CITY OF MERCER ISLAND

Pre-Application Meeting (PRE22-012)

Site Location:	6221 83 rd PI SE	Parcel Number	545420-0220
Lot Size:	10,017 sf	Zoning:	R-9.6 (Single Family)
Brief Project Description:	Demo existing SFR. Build new SFR. Located in geohazard areas.	Documents Provided:	Project narrative, preapplication questions, conceptual plans, arborist report.
Applicant Information:			
Name:	Julian Weber	Email:	dpd@jwaseattle.com
		Phone:	(206) 953-1305
Second Pre-application Meeting Required:	Not Applicable	Click for explanation if necessary

3 Diagram Lot Coverage
SCALE: 1" = 10'-0"

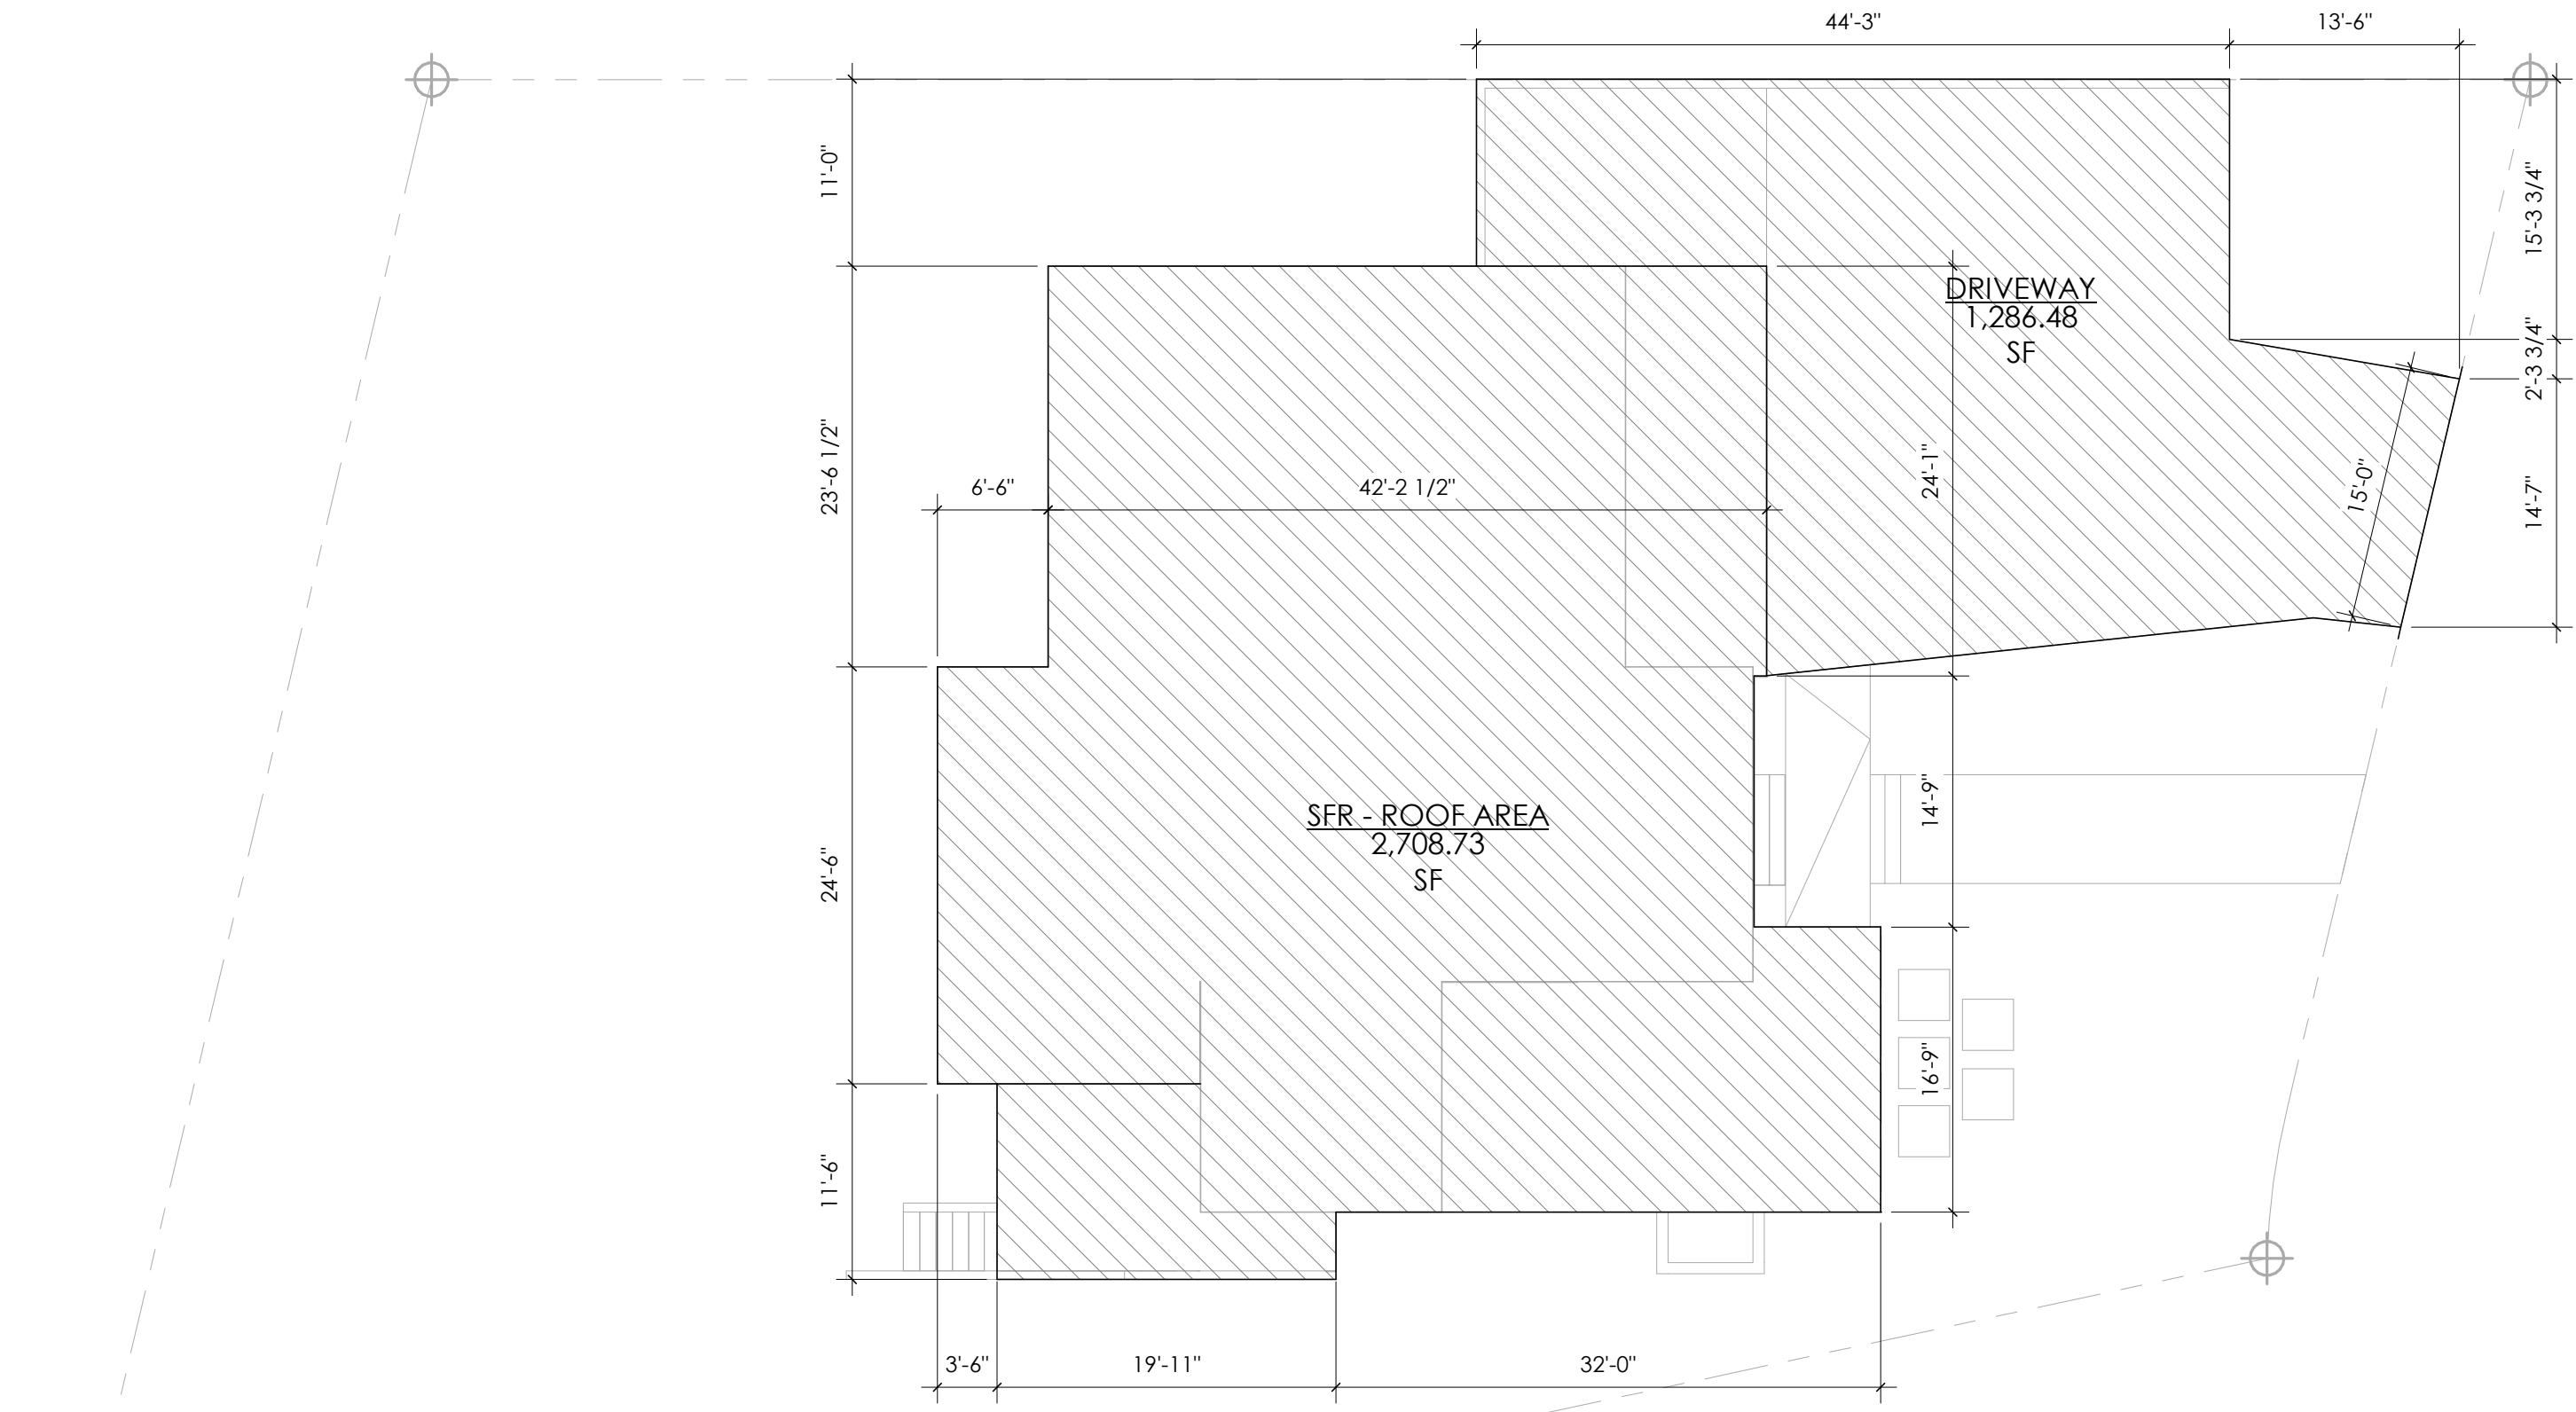
- 4. Lot slope calculation was not provided, nor were lot coverage calculations. We are unable to determine applicable lot coverage of if proposed lot coverage complies based on information provided.
